## Planning Consultation Memo

Date	Planning Officer	Environmental Health Officer
05/02/19	Gill Claxton	Karl Riahi
Planning Application Number	Worksheet Number	
6/2018/2768/OUTLINE	WK/104712

**Address:** Hatfield Business Park Hatfield AL10 9SL

**Application Details:** Outline application for a large-scale mixed use development including 1,100 new homes and supporting infrastructure including a primary school, local centre and open space with all matters reserved

Illustration of noise survey locations

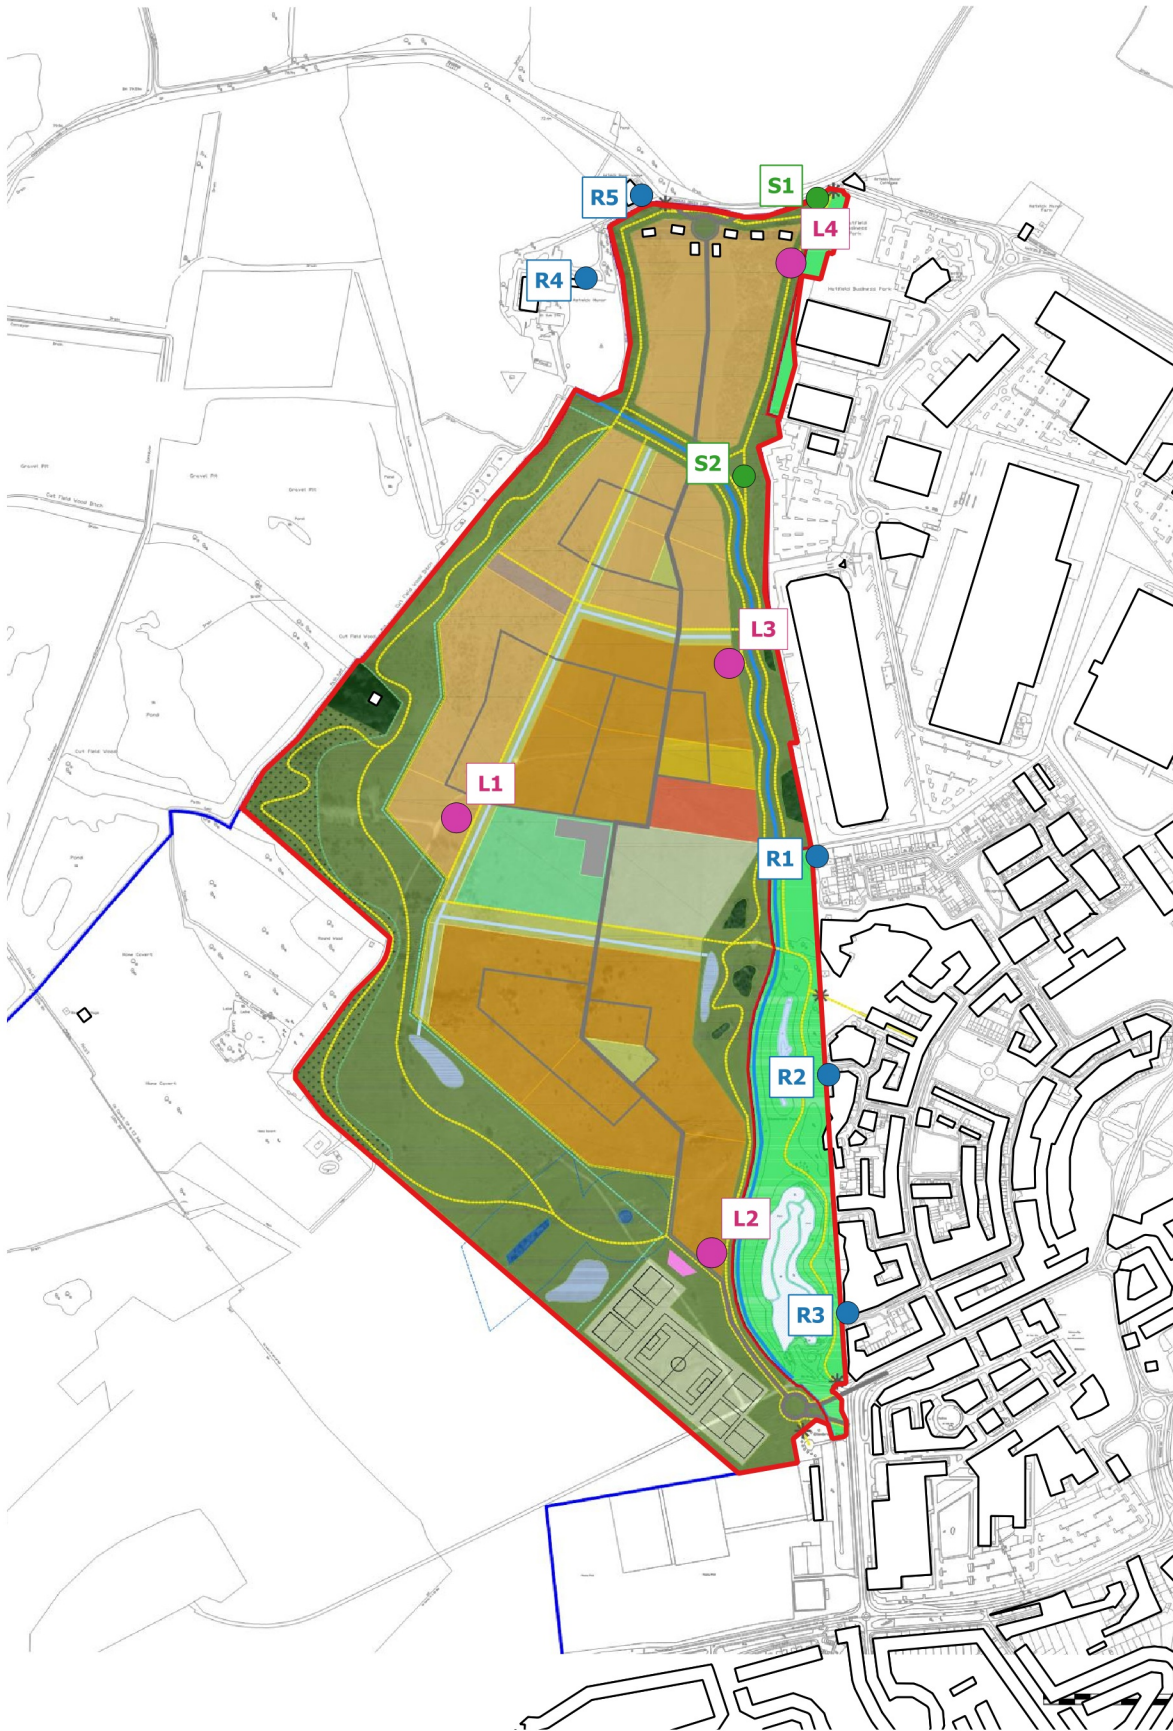
There are concerns over noise from existing commercial/ industrial uses within the area. Chapter 9: Noise and Vibration of the Environmental Statement provides information on an unattended BS4142 assessment which took place using recordings, this is not seen as the best way to undertake such an assessment.

We would expect to see a manned assessment with subjective descriptions of the type of noise occurring along with LA<sub>max</sub> noise data to get a better understanding of the overall noise climate associated with the commercial/ industrial units. Additional information on operating times would also help get a better idea of the potential impact.

We will require full BS4142 assessments for the existing commercial/industrial units and noise from quarry operations on the development.
